Conservation consultation response

From: Jennifer Ballinger <Jennifer.Ballinger@Cherwell-DC.gov.uk>
Sent: 06 September 2021 17:42
To: Gavin Forrest <Gavin.Forrest@Cherwell-DC.gov.uk>
Subject: 21/02409/F - Mawles Farm, Main Street, Sibford Gower

Thank you for consulting the Conservation and Design Team on the above application.

Title Pound Lane Elevation

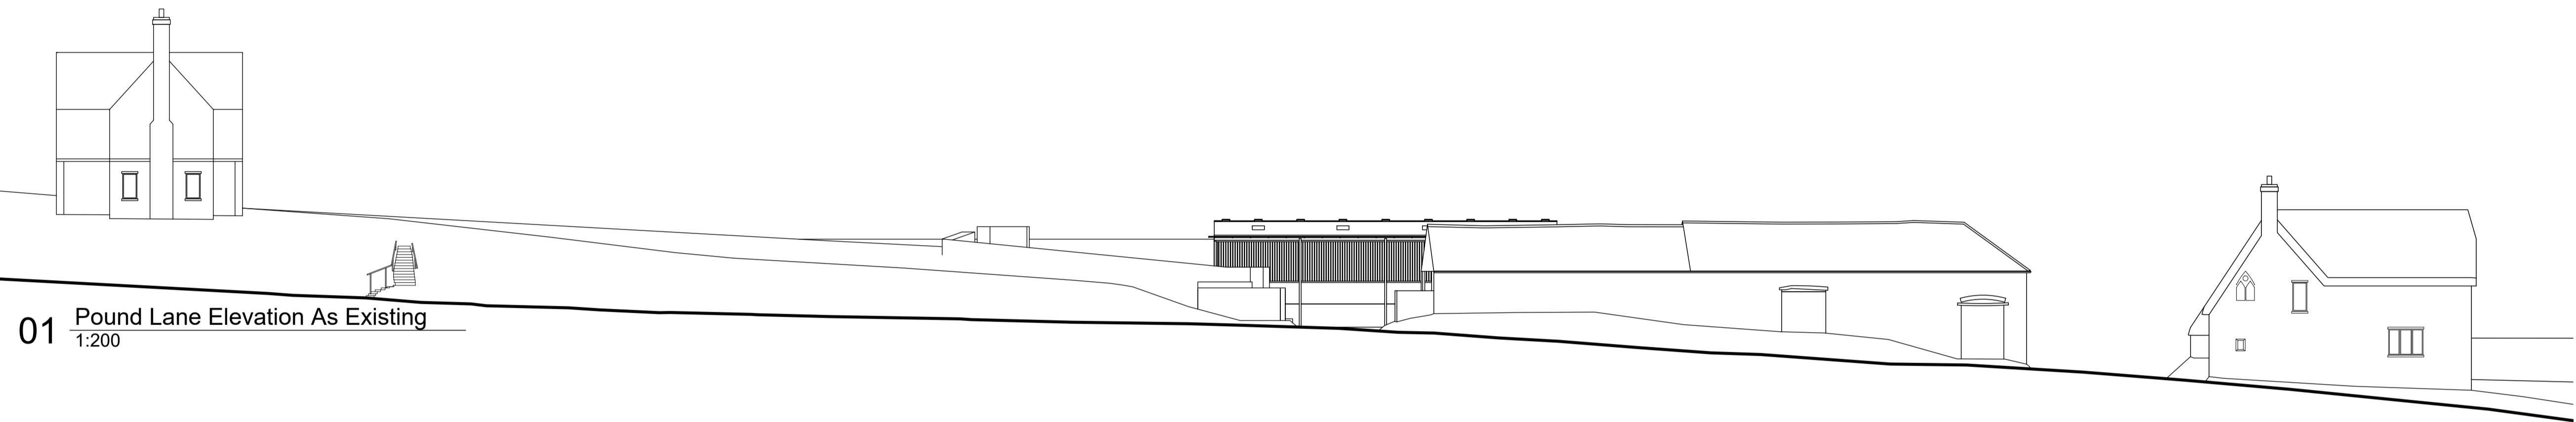
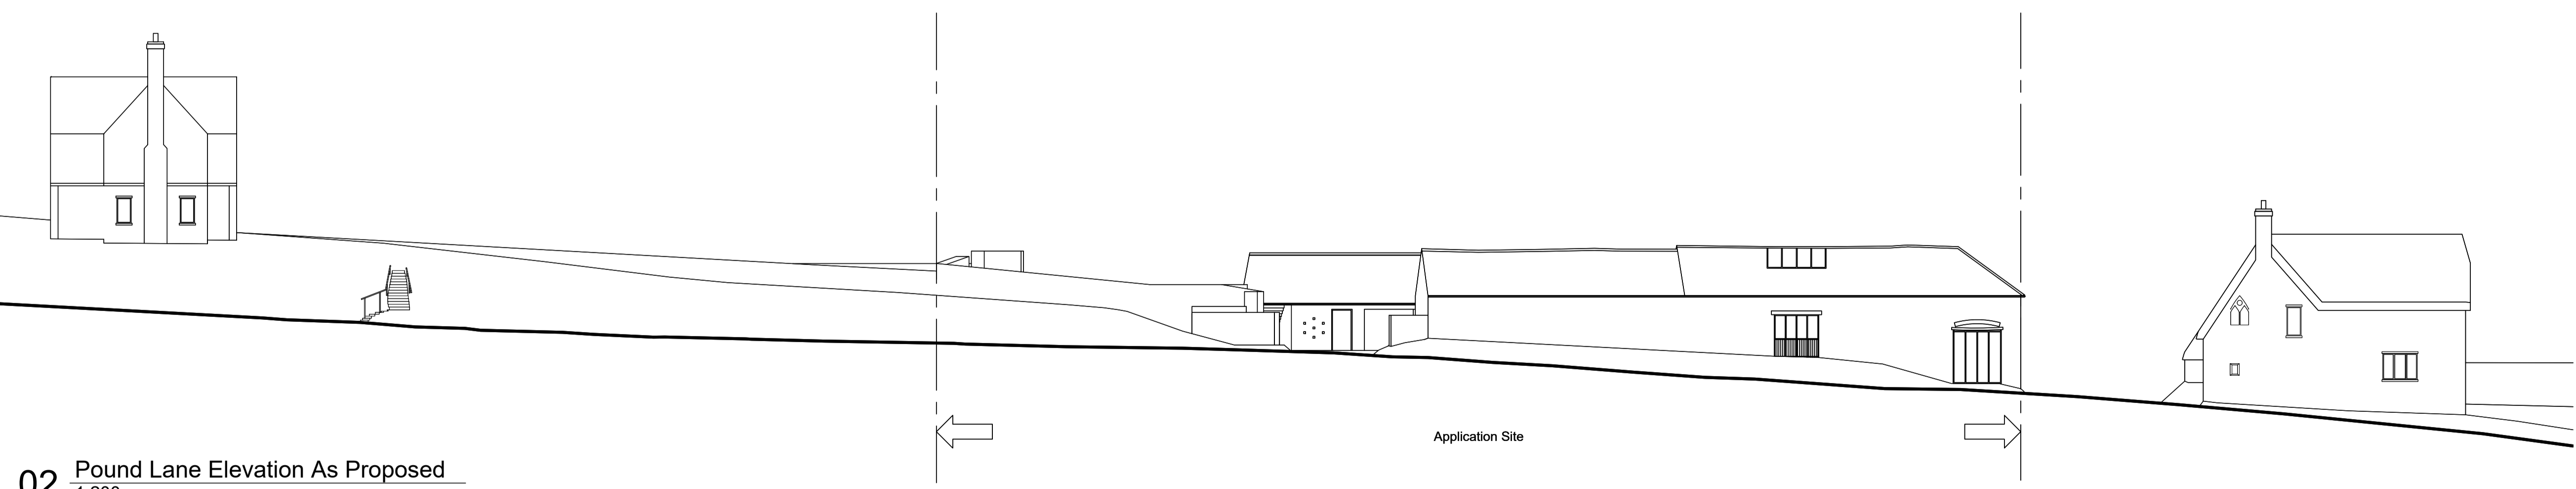
It is noted that the positioning of rooflights have altered, but there are no objections as there are no additional rooflights on the street frontage. There are, however, some concerns with the proposal for the ridge light roof windows which are additional and will be visible from the streetscene.

It is noted that there are no additional openings on the street frontage, which is welcome.
